I have reviewed and highlighted concerns in the following areas:

Written Representation from Diane Abbott

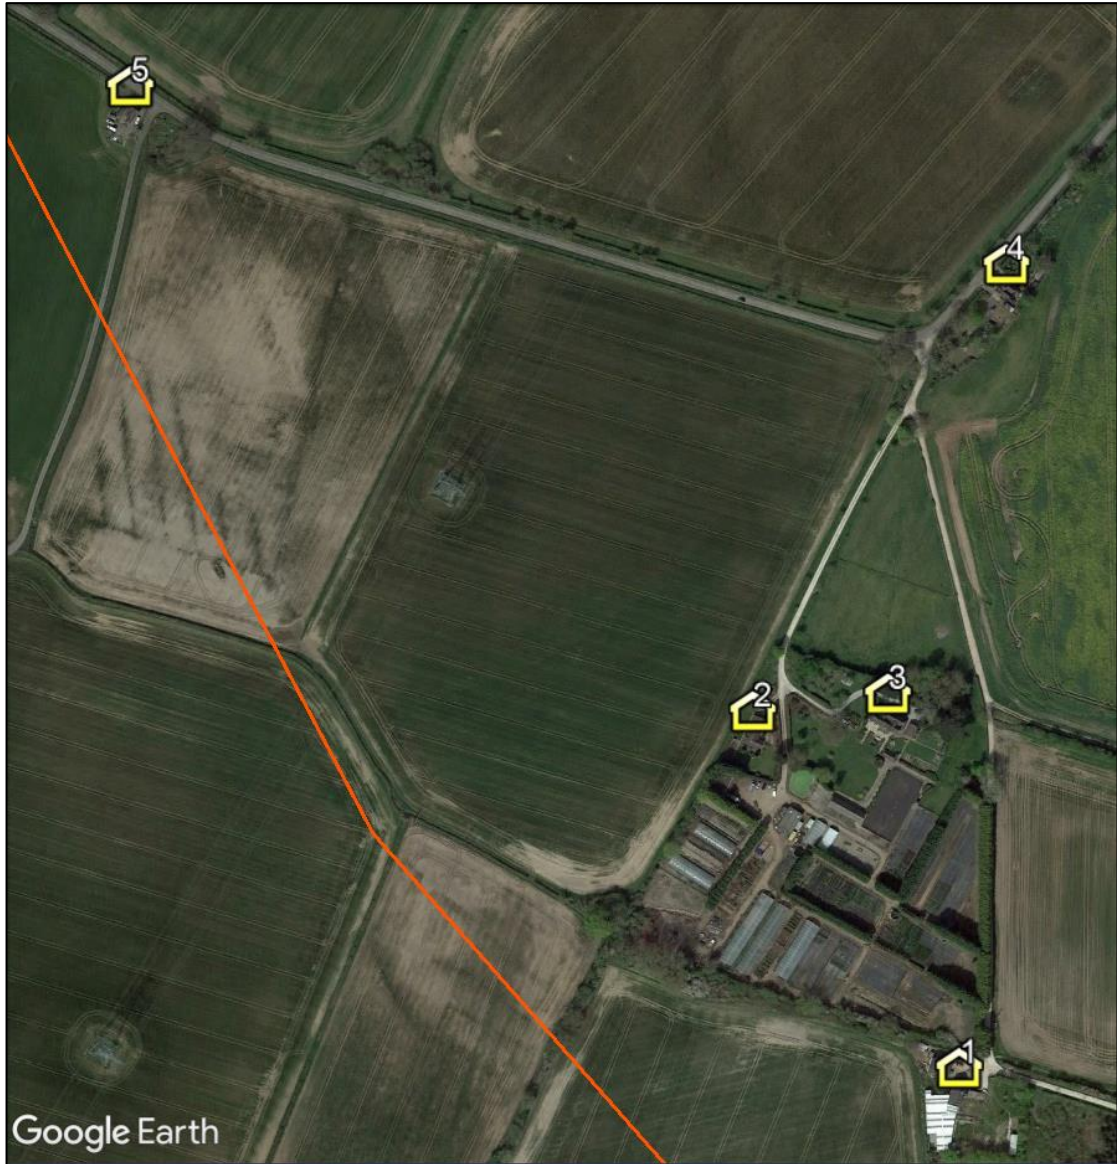
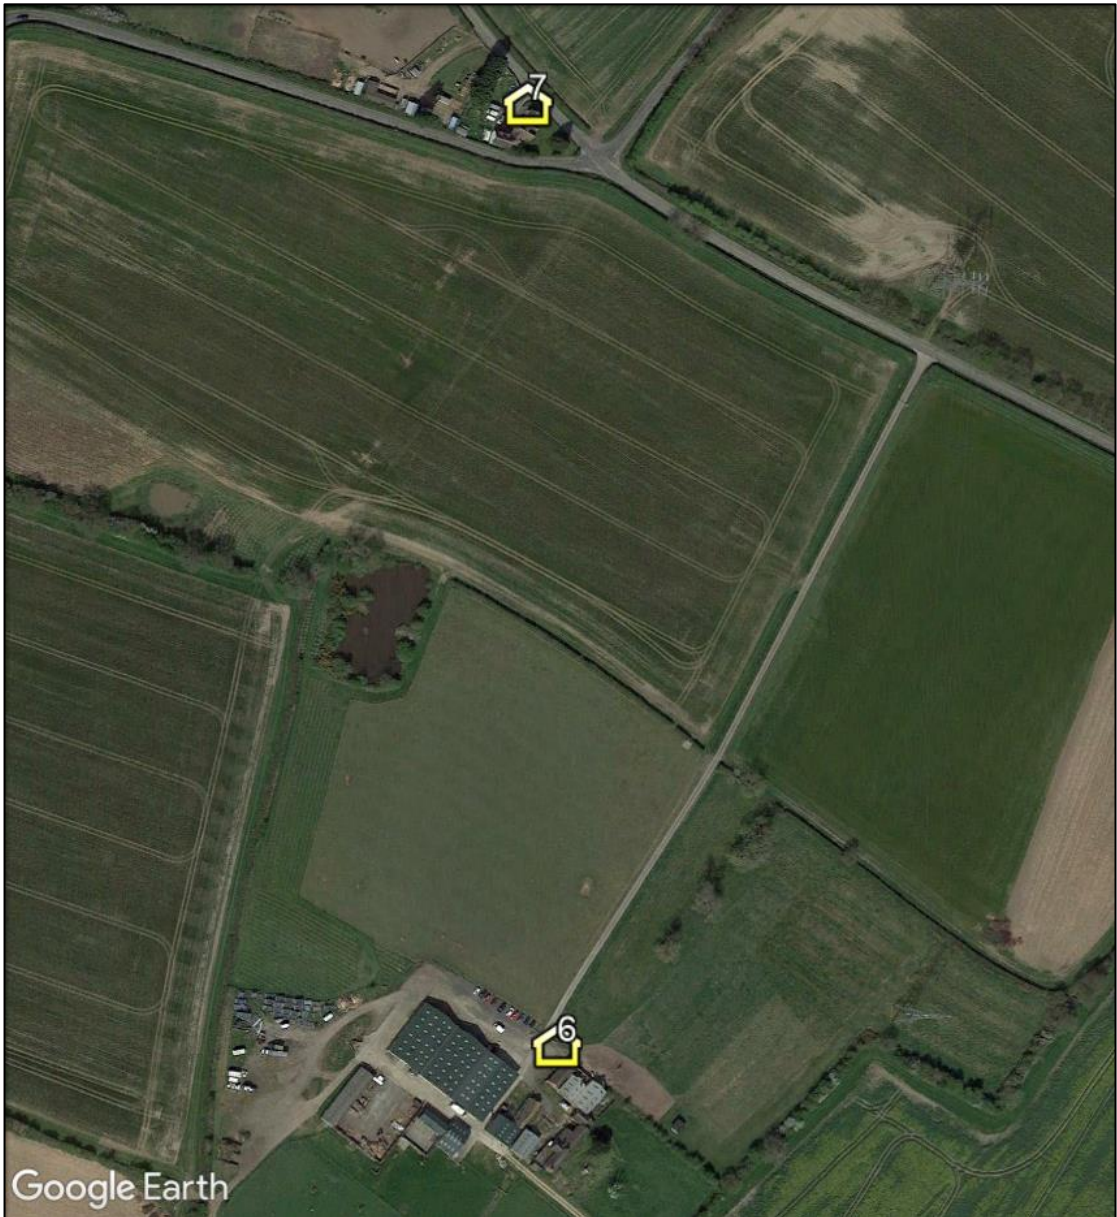
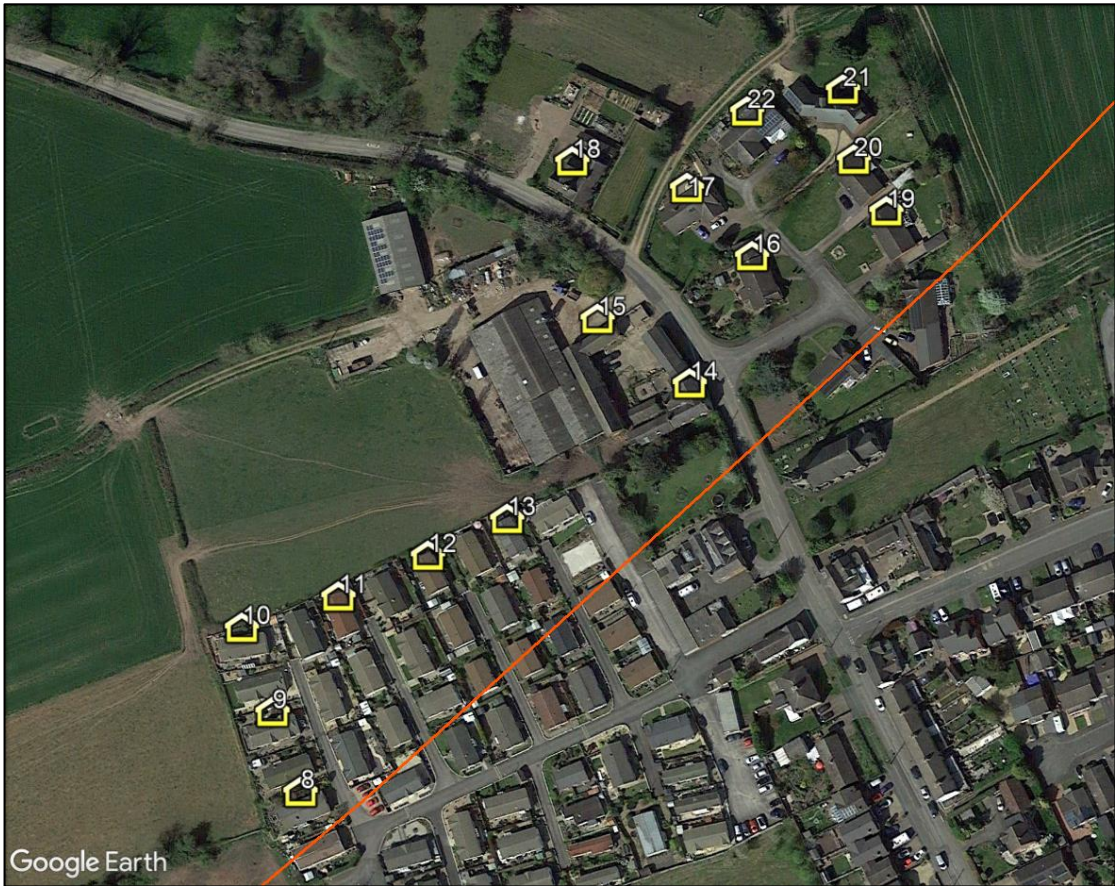
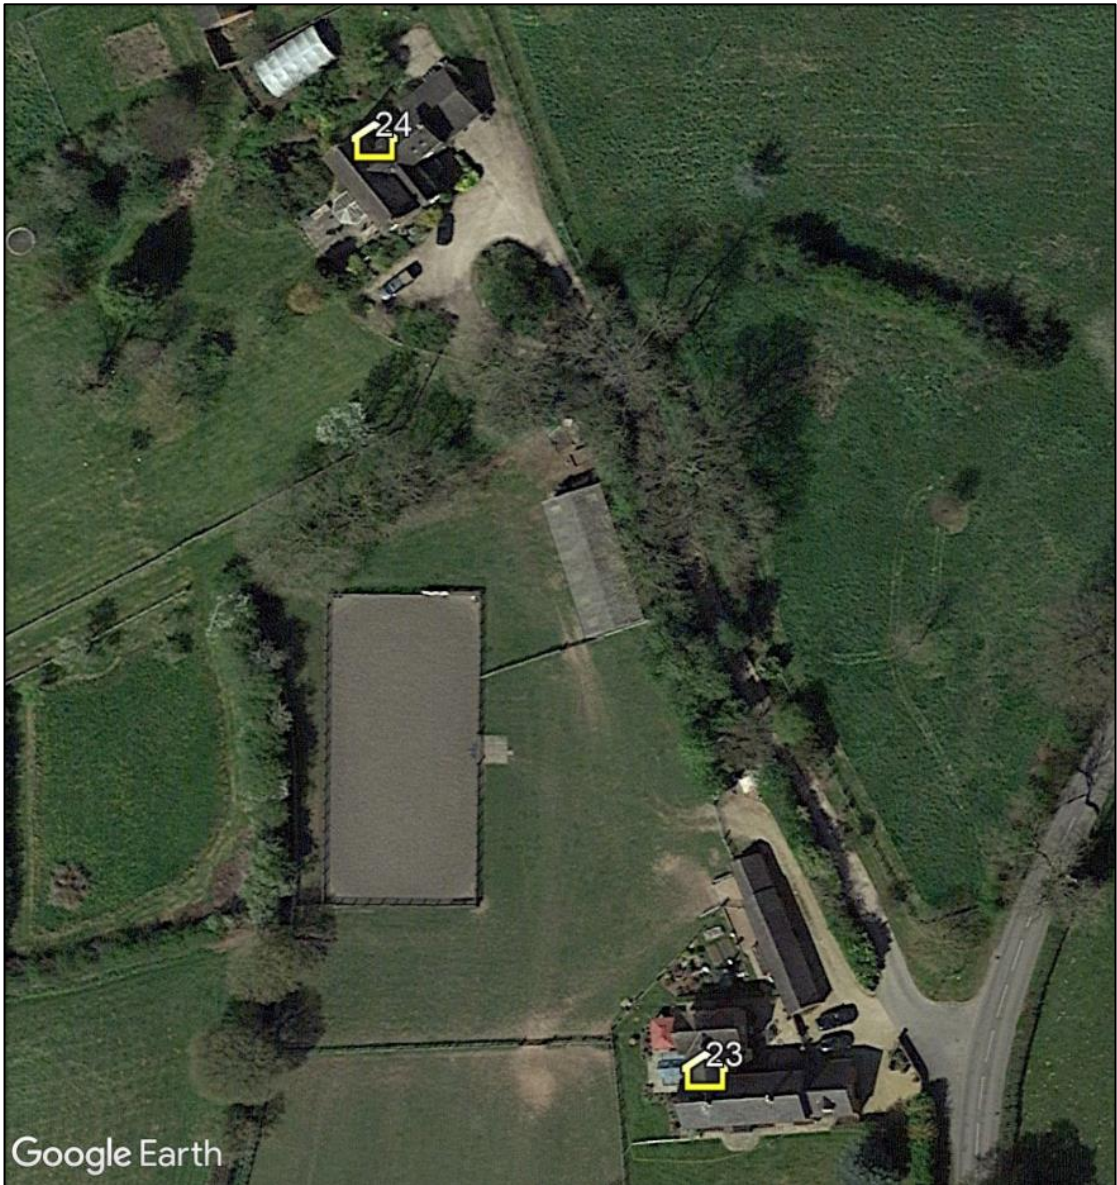
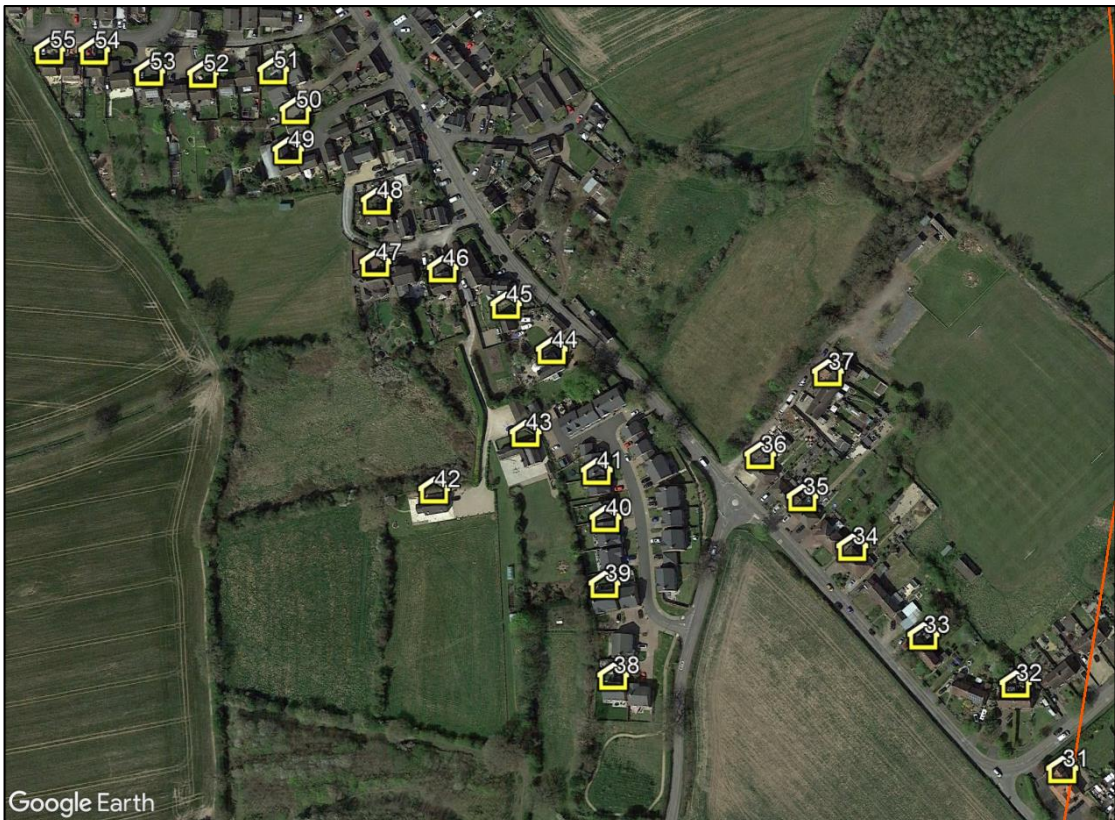
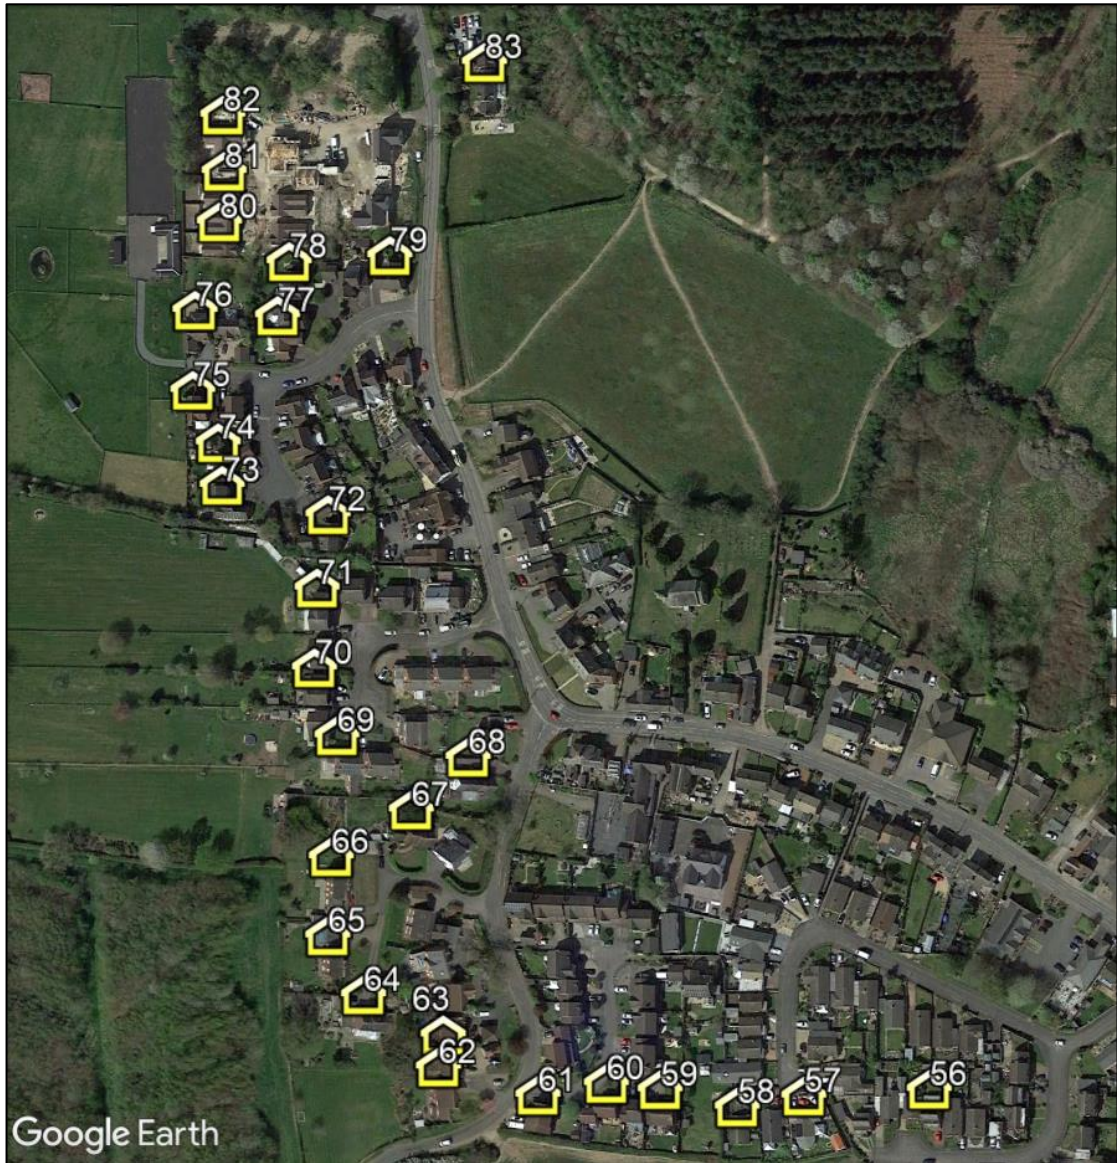
- 4.3. My primary concern is that the Glint and Glare analysis models only the mid-point of the solar panels at 1.75m height, rather than using the full height of the panels which is 2.7m. (See Section 2.2 of Appendix 14.1). As many of the surrounding hedges are between 1.5m and 2m tall, this will greatly underestimate scale of glint and glare effects.

- 4.7. It is clear from this guidance that BOTH the maximum and minimum heights of a solar array should be modelled.
- 4.8. I request that the Glint and Glare analysis is repeated using the maximum height of the panels, so that it can be proven that no further areas are identified as being at risk from solar reflections that would require mitigation.
